7695 Ponca Road, Turf Master, LLC., VA-24-8

Please accept the following comments from El Paso County Public Health (EPCPH) for the variance request referenced above:

TURF MASTER VARIANCE OF USE

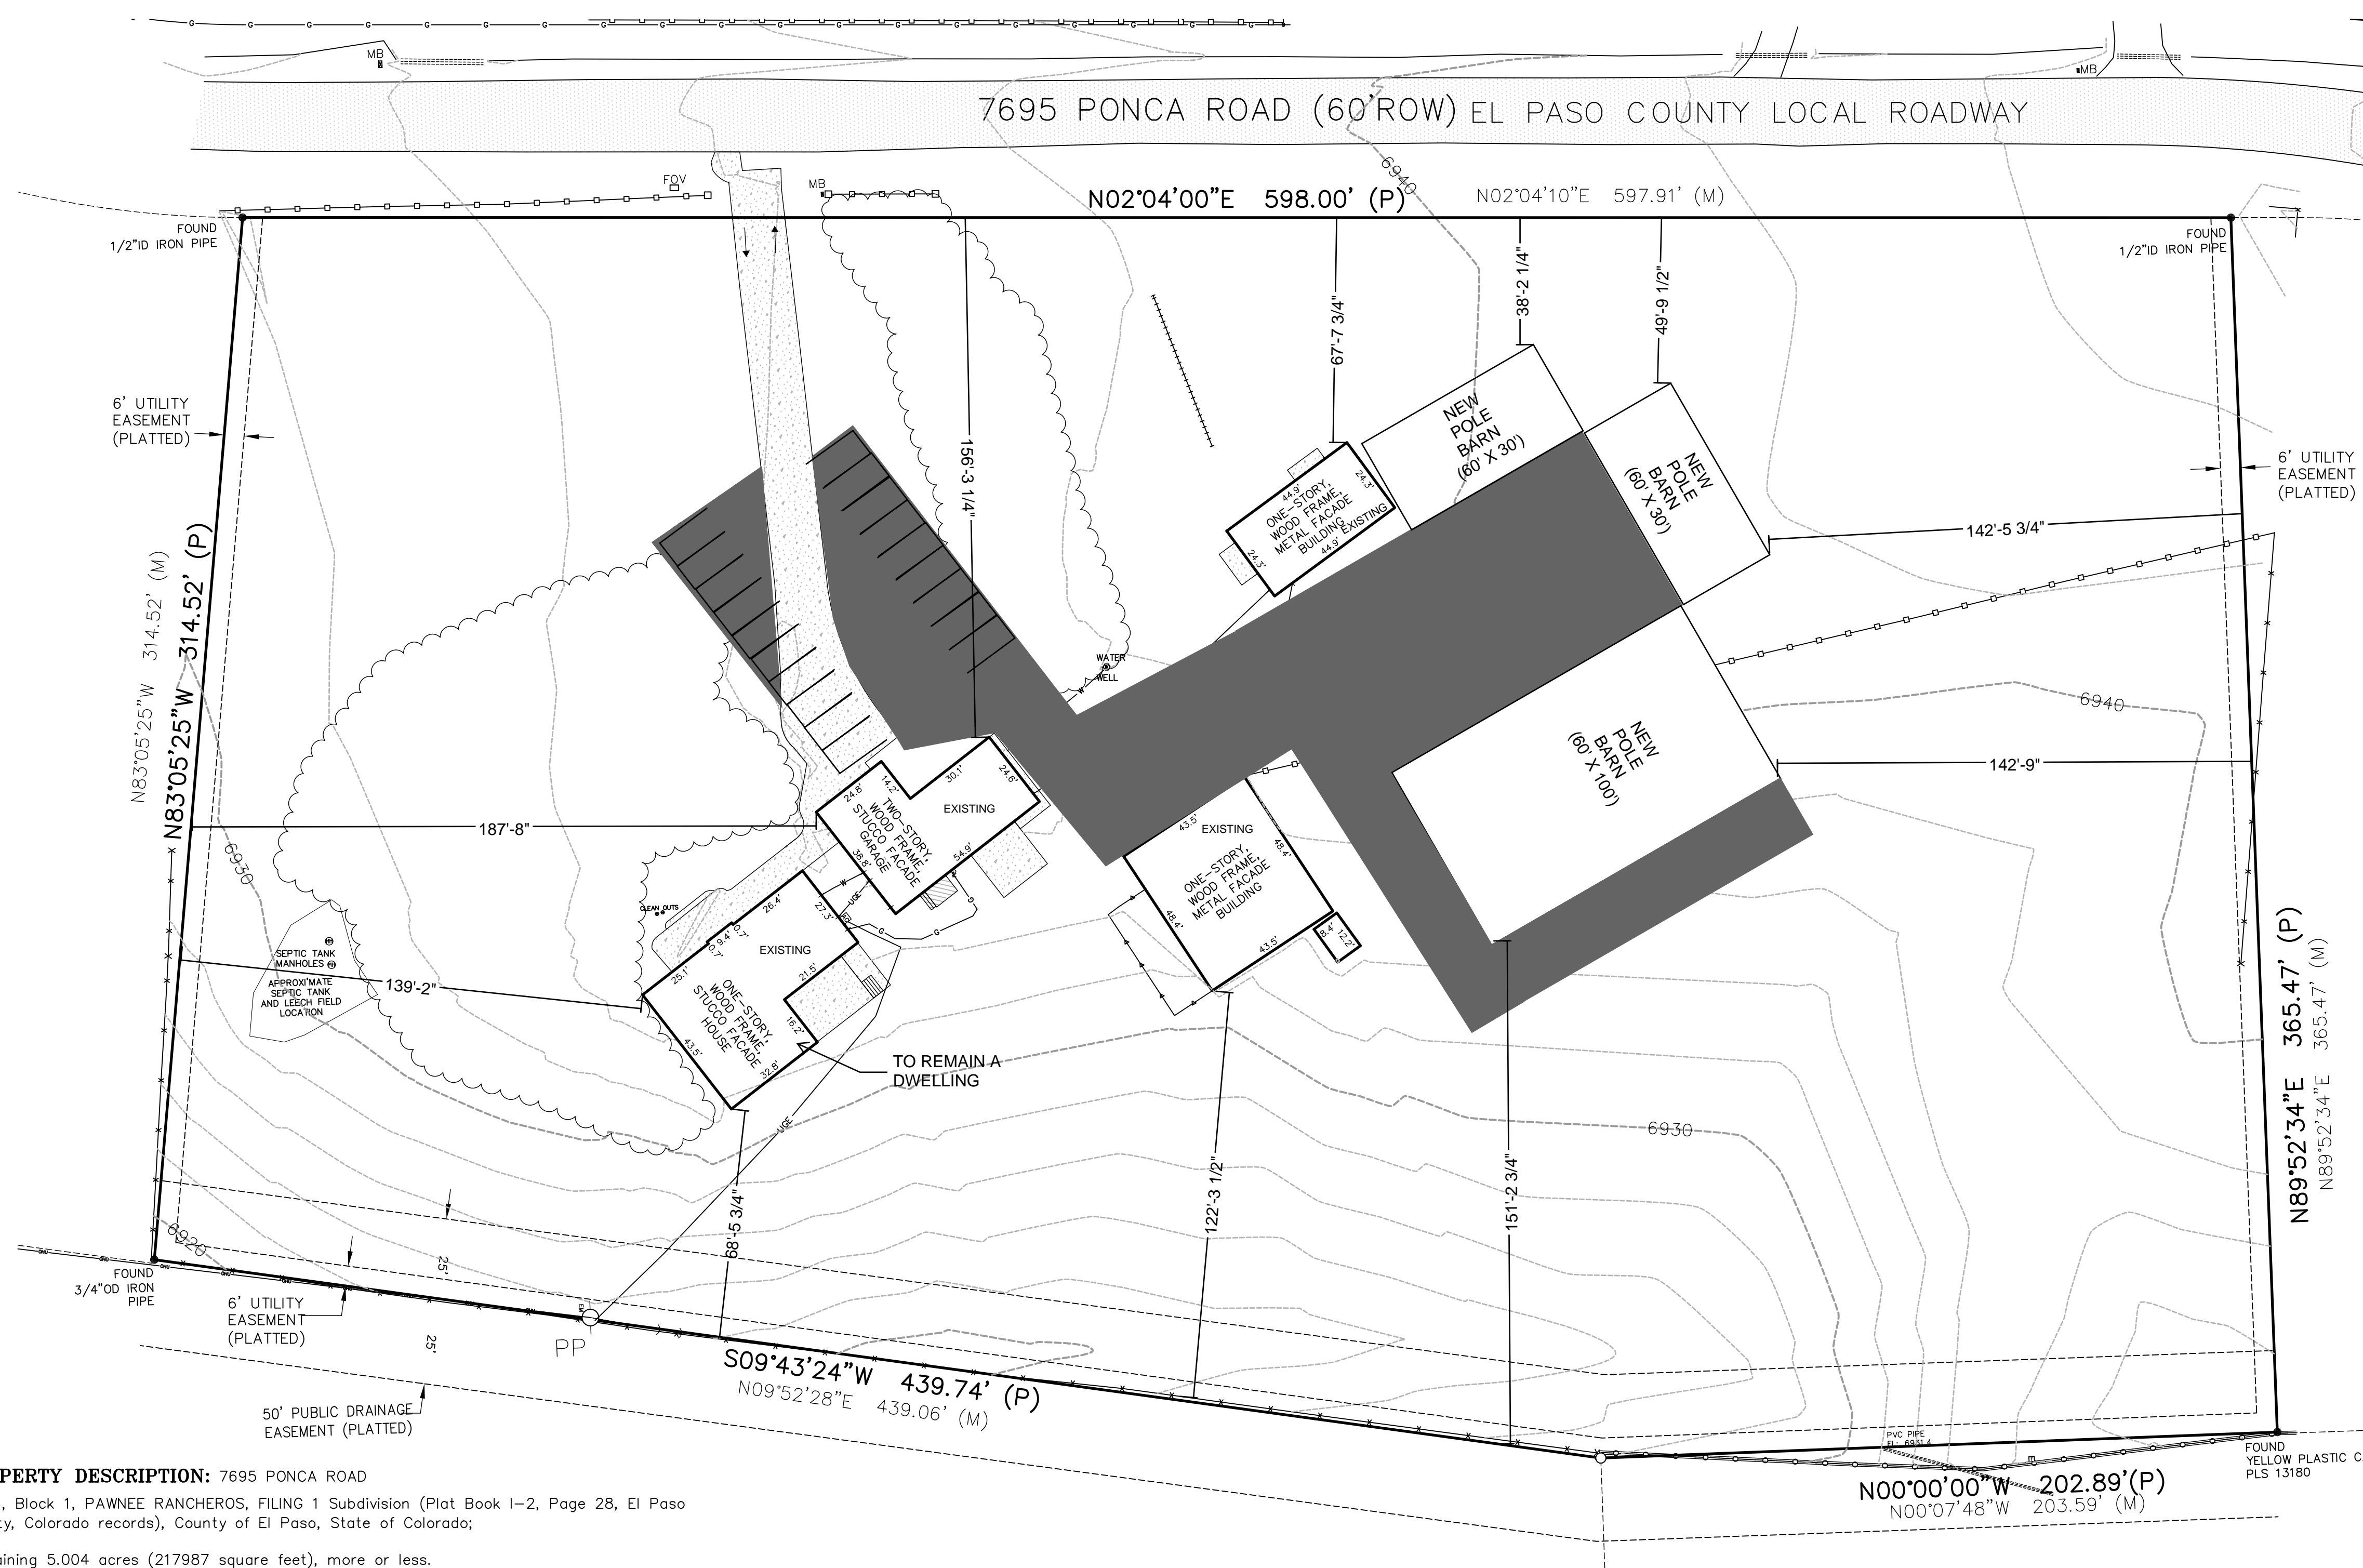
- **Water service for the existing house is an existing individual private well.**
- **Wastewater service for existing house is an existing onsite wastewater treatment system (OWTS) permitted and approved by El Paso County Public Health (EPCPH) in 1975.**
- **All components of the OWTS (septic tank and soil treatment area) must be located and protected from compaction by vehicles and the business operation. Adequate area for replacement of the existing soil treatment area, should it be necessary, must also be protected from compaction.**
